TO: Community Development Services  
FROM: Public Works Planning Review Team  
DATE: March 24, 2021  
SUBJECT: BL-21-00003 Ahlers

The Public Works Department has reviewed the Request for Boundary Line Adjustment and finds that it meets current Kittitas County Road Standards.

SHEET  
 1  
 OF  
 2

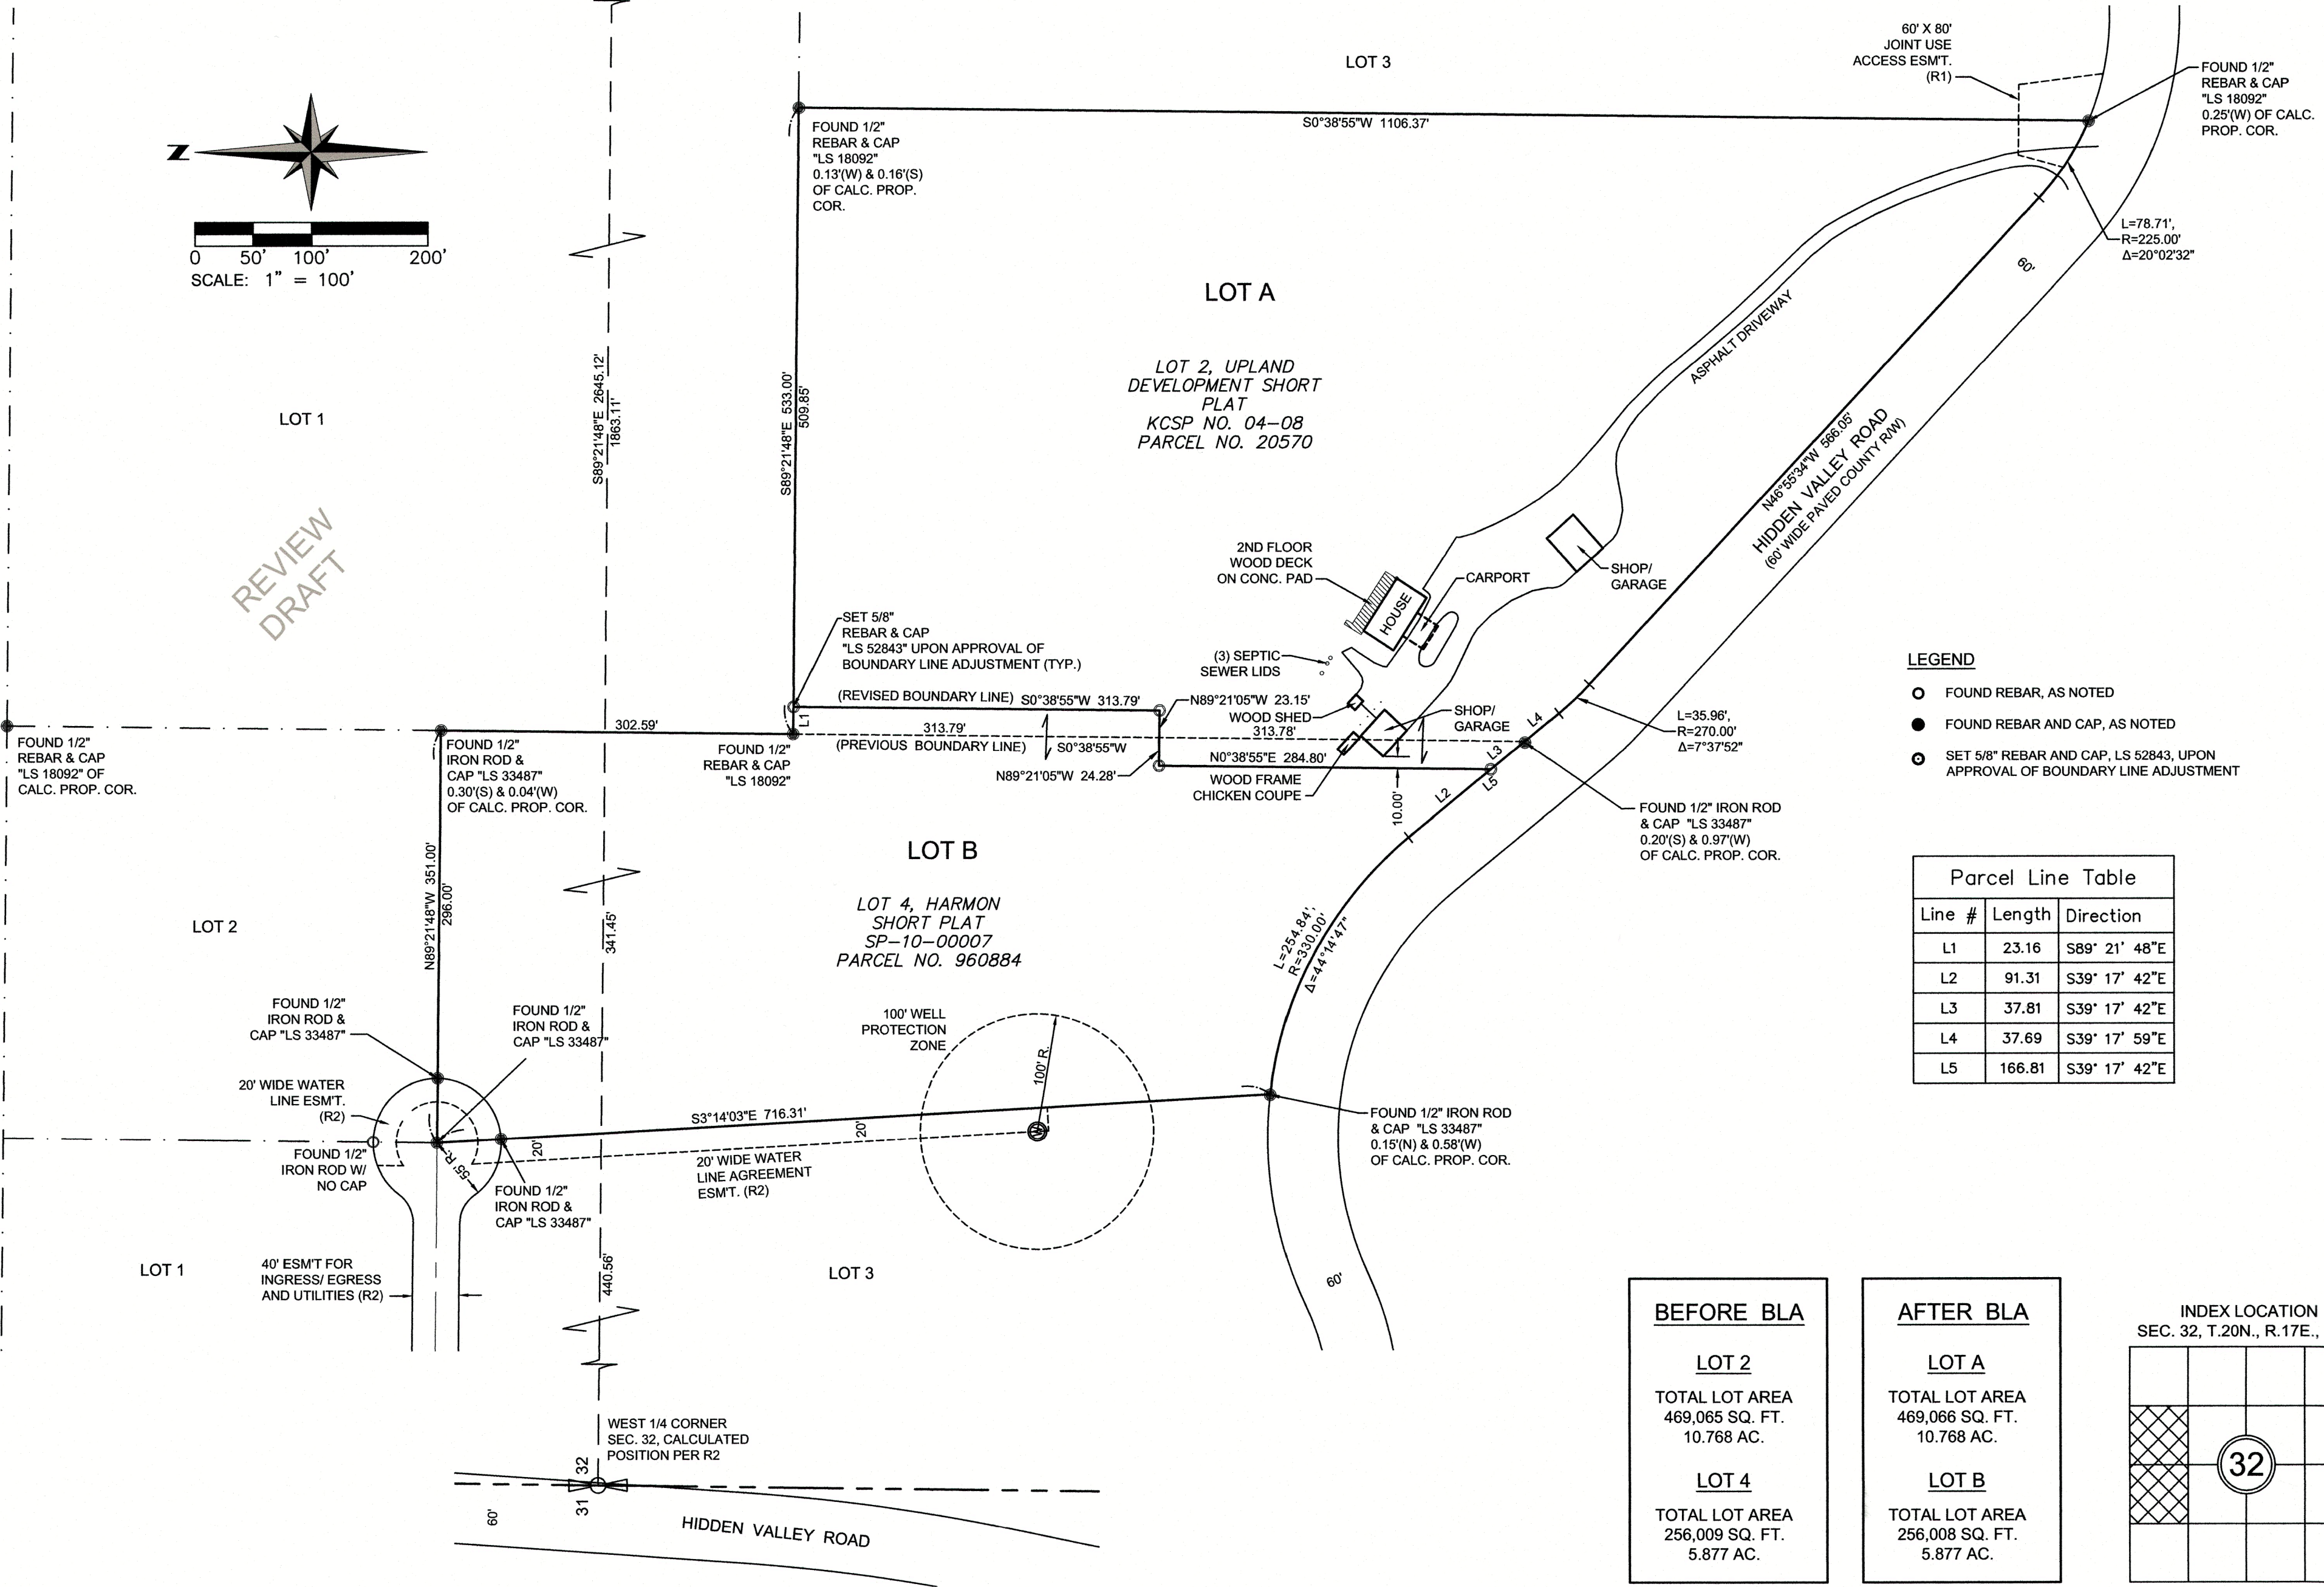
1. The northernmost found property corner contains some unclear language. Additionally, it does not show bearing and distance ties to this corner.
2. The Section corners shown as calculated do not have any ties to link this to the boundary survey. As this line is the Basis of Bearing (by reference), it should be tied.

SHEET  
2  
OF  
2

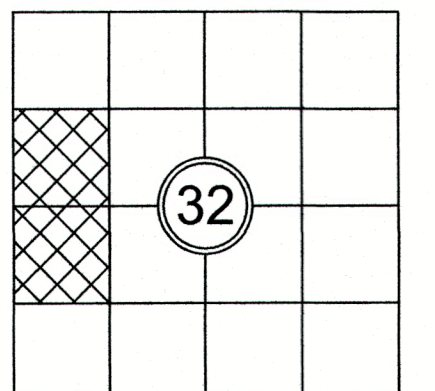
3. There is a discrepancy with the transfer parcel being added to Lot 4. If the legal description described North portion of West portion, the South line should be parallel to the North line, rather than perpendicular to the West line (per standard survey practice). One solution would be to add "as measured parallel and perpendicular to the North-South Line" to the legal description.

5. The second to last call of the revised legal description for Lot A should be changed to the following: "Thence S89°21'05"E for 24.28 feet to the East line of Said Lot 4;"
